Charlotte Storm Water
600 East Fourth Street
Charlotte, N C 28202-2844

Rezoning Petition Review

Date of Review: December 29, 2020 (***Revised January 20, 2021***)

Rezoning Petition #: 20-160

**Aldersgate Rezoning #2020-\_\_\_**  
3800 Shamrock Drive  
Charlotte, NC 28215  
Date: 10/02/2020 Rezoning Submittal  
Project ID: 17048  
**Proposed Rezoning Technical Plan**  
**RZ-01**

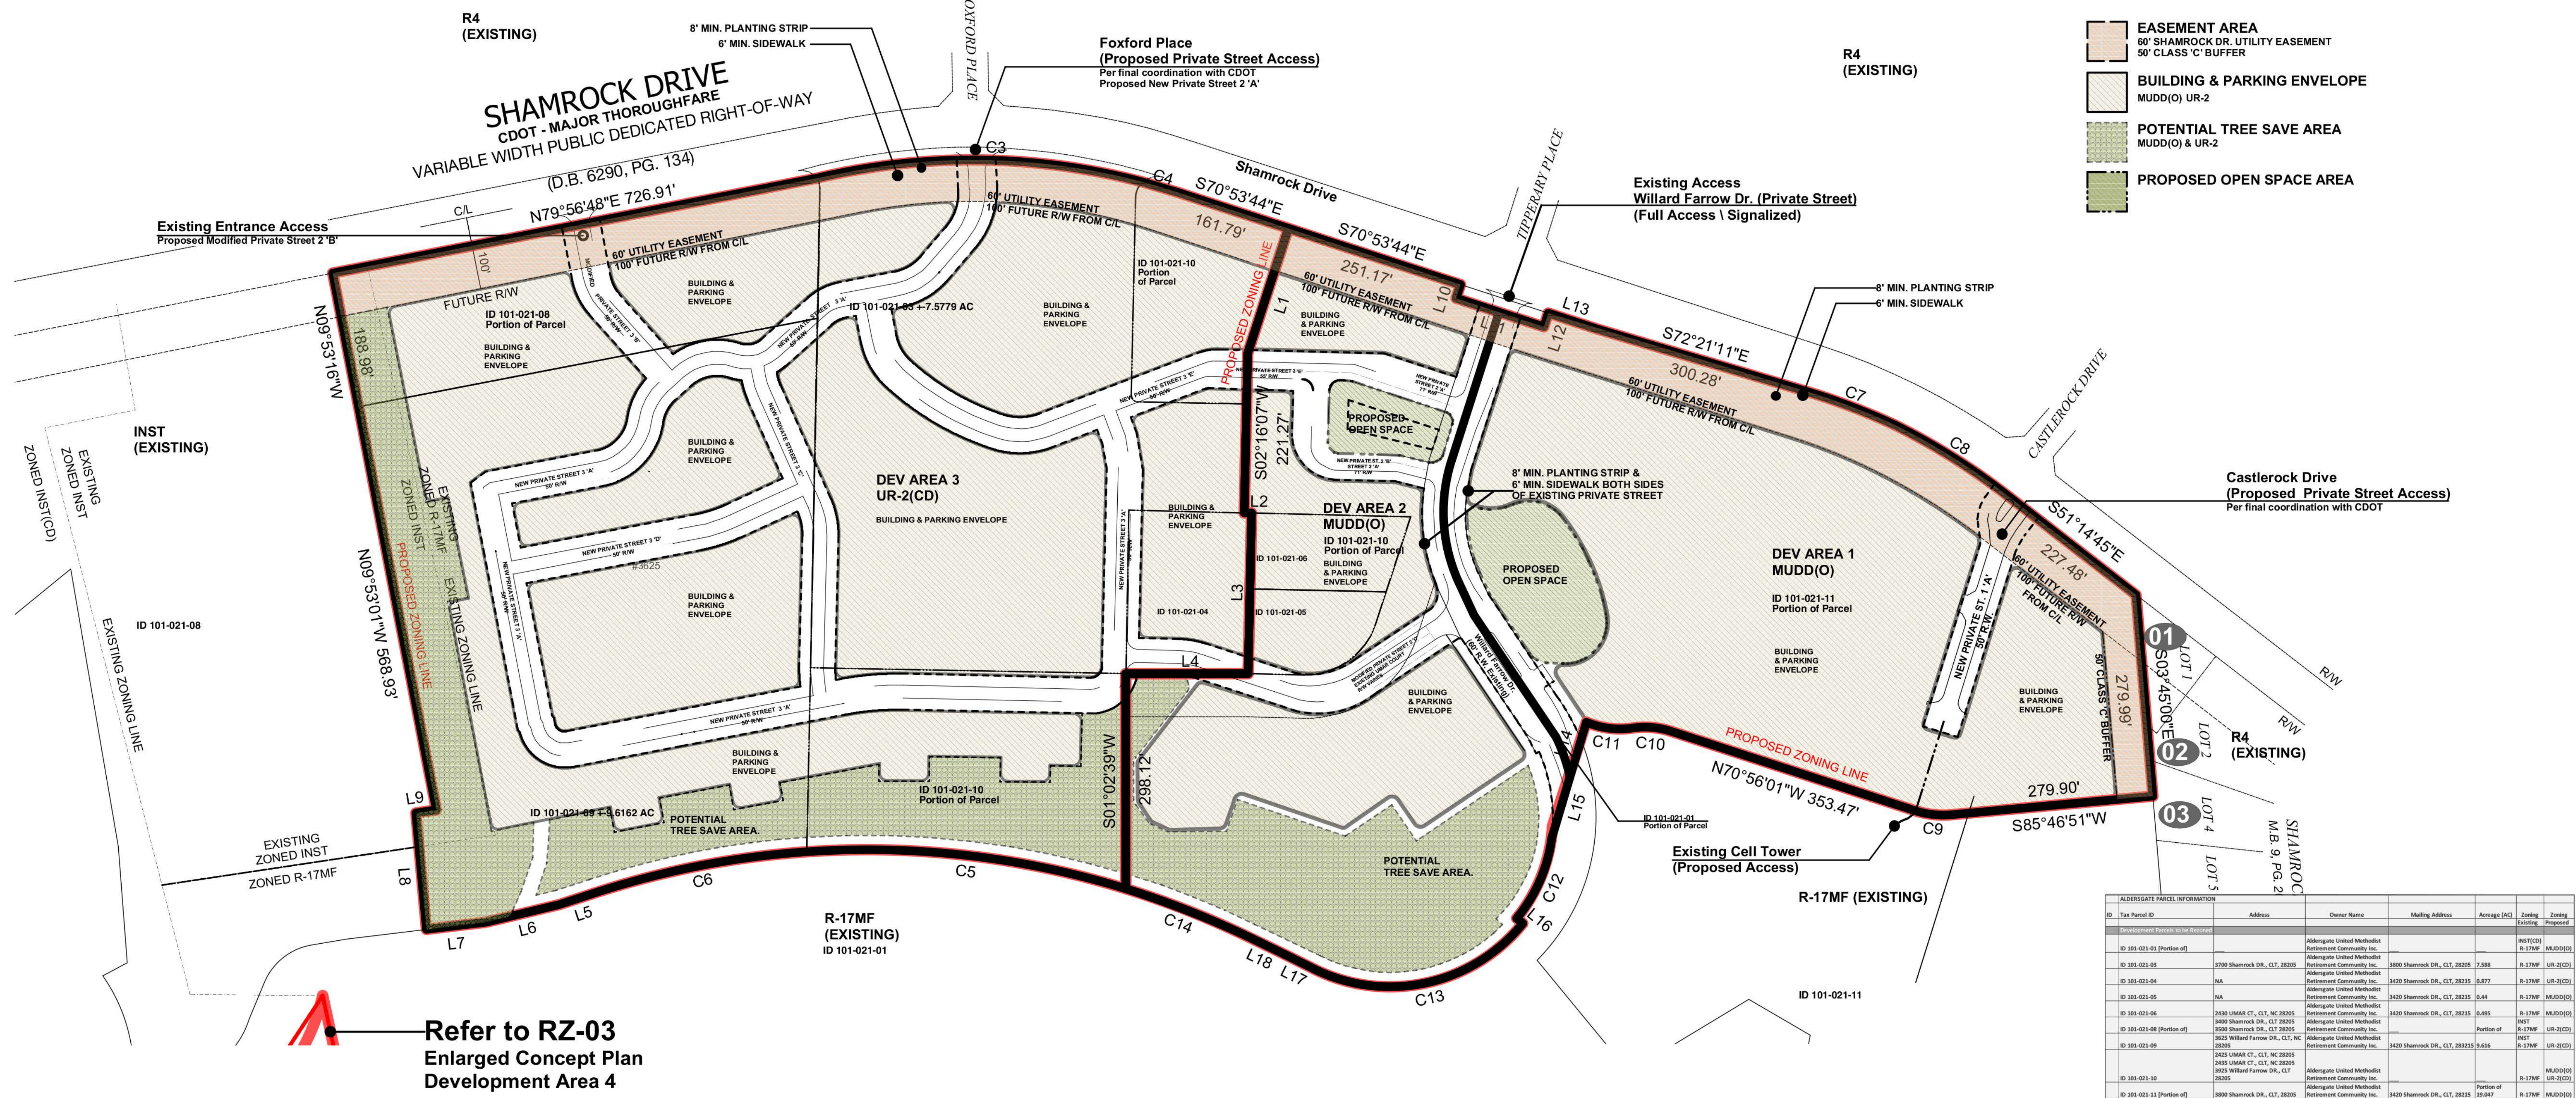
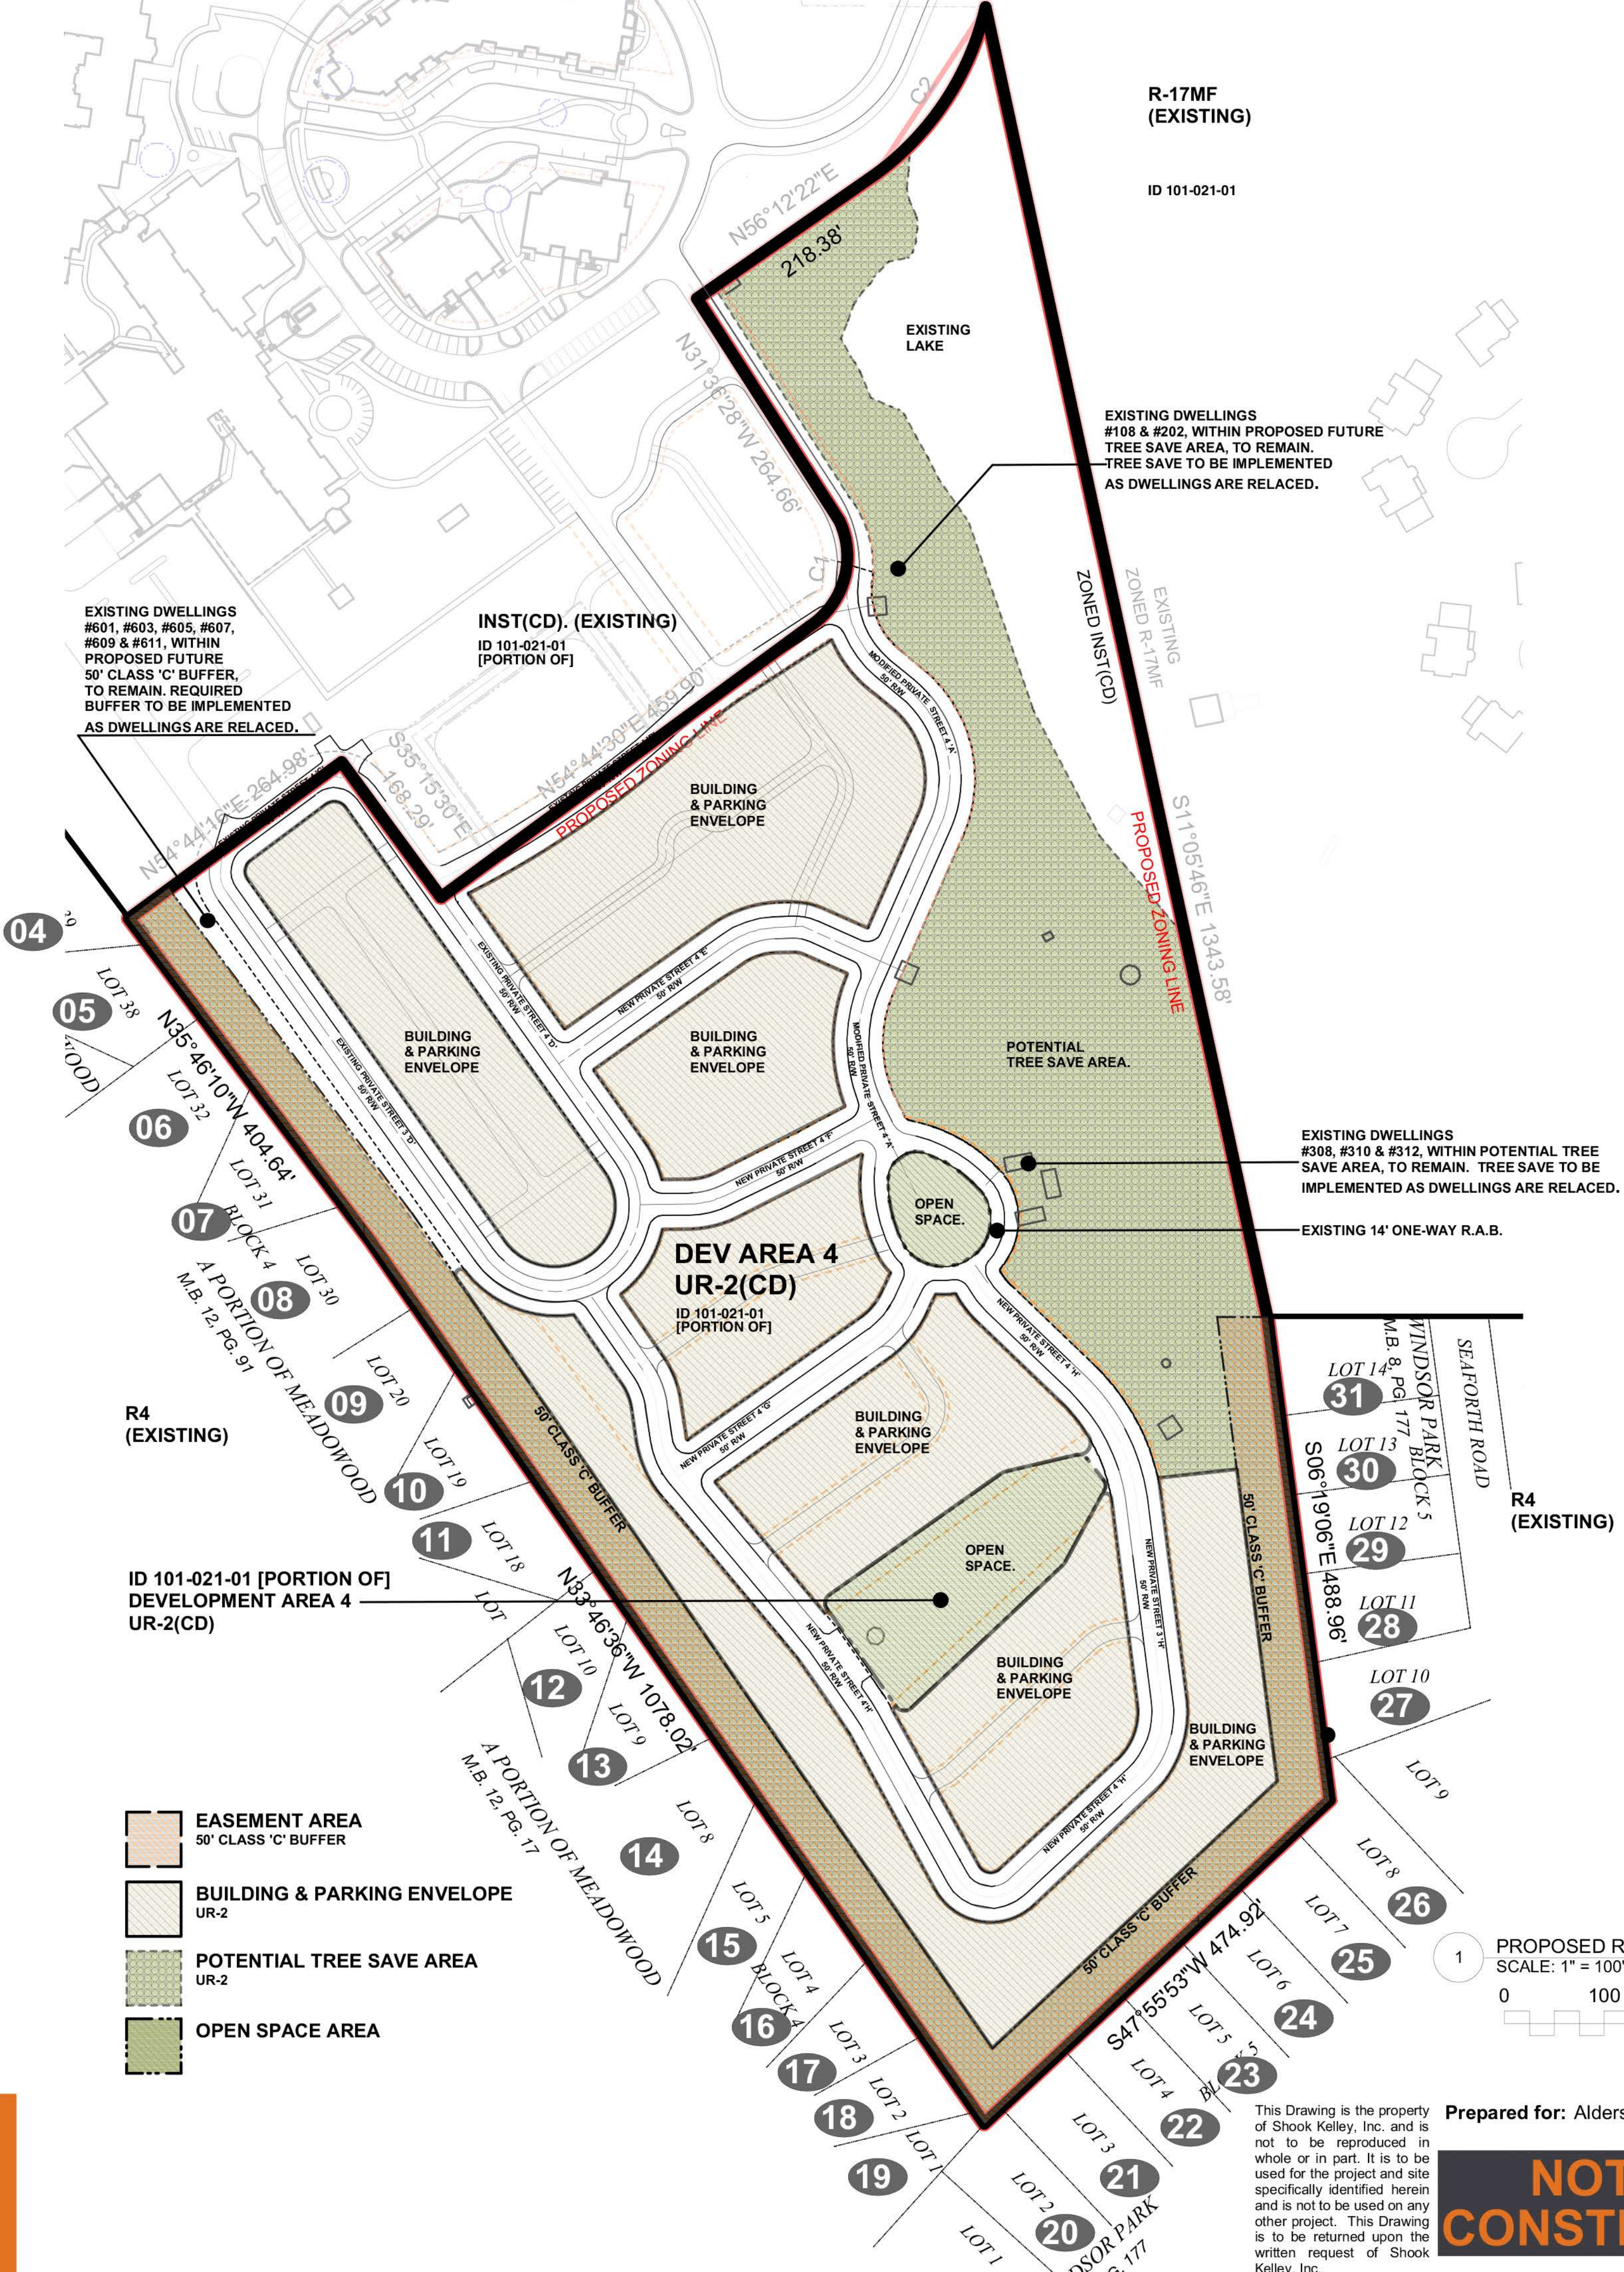
Recommendations Concerning Storm Water: City of Charlotte GIS data indicates a 30-ft PCSO buffer and 50-ft PCSO/SWIM across the site. Please show and label *Potential 30-ft PCSO Buffer* and *Potential 50-ft SWIM/PCSO Buffer* on the site plan. Any increase of impervious area within such buffers may not be allowed and is not approved with the rezoning process. Stream Delineation Reports are subject to review and approval by Charlotte Storm Water Services.

Please include the following note under Environmental Features:
“Development within any SWIM/PCSO Buffer shall be coordinated with and subject to approval by Charlotte-Mecklenburg Storm Water Services and mitigated if required by City ordinance. Petitioner acknowledges intermittent/perennial stream delineation reports are subject to review and approval upon submission of development plans for permitting and are not approved with rezoning decisions.”

Due to revisions (1/20/21): No additional recommendations are needed at this time.
